Ribble Valley Borough Council Planning Dept,
Council Offices
Church Walk
Clitheroe
BB7 2RA

Ref:- Planning Application 3/2023/0937

I write to express my concern with the proposed upgrade on the properties on the Kirkfield Estate and in particular the works highlighted in the planning application documents at number 9, the

Proposed Property Elevations

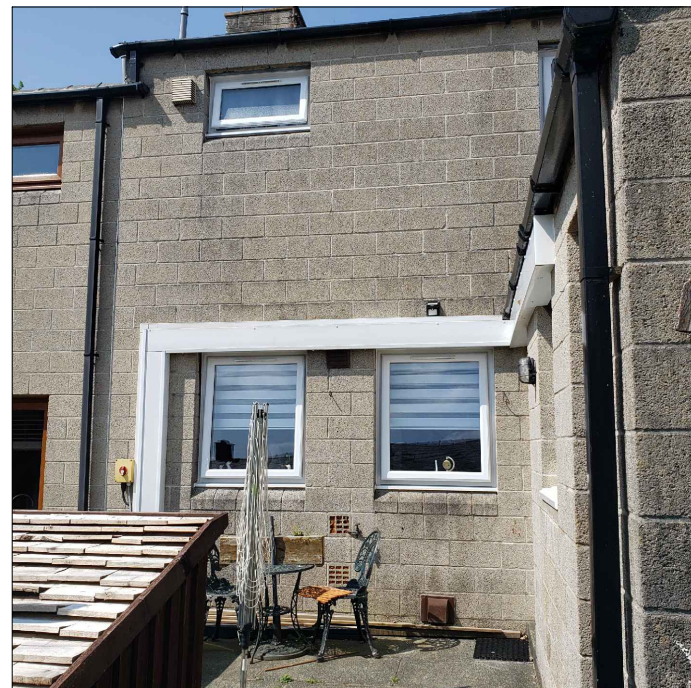
- 1. Finish Detail to intersection of insulation to Garden and Backyard walls.**

How does the contractor intend to finish the insulation where it abuts to the

2. Gutter Alterations at high level where [REDACTED].

How does the contractor intend to make alterations to the adjoining guttering as number 9's walls will now protrude an additional 40mm plus any additional render thickness?

- 3. Backyard fence reduction in length to accommodate insulation to number 9's back wall.**
It is assumed the back yard timber fence will be reduced in length to accommodate the insulation and render; how will the contractor rectify this?

4. Finish detail to short gable on roof.

As shown in the gables images there are 2 flashing details on the gable of number 9, how does the contractor intend to finish these details and [REDACTED] should [REDACTED] s problem in the future?

5. Access to lead flashings on gables of Number 9

How does the contractor intend to access the gable safely?

6. Making good of any damage caused by access to roof gables.

If the contractor was to need [REDACTED] and should any damage occur, will he be making good the damage?

Hoping these images and highlighted points make sense as the planning drawing doesn't give any details of fixing or overall construction details. Also, whilst walking the estate it is thought we'd be the only householders effected in this way as all other houses listed either seem to be other configurations or adjoining housing association homes.
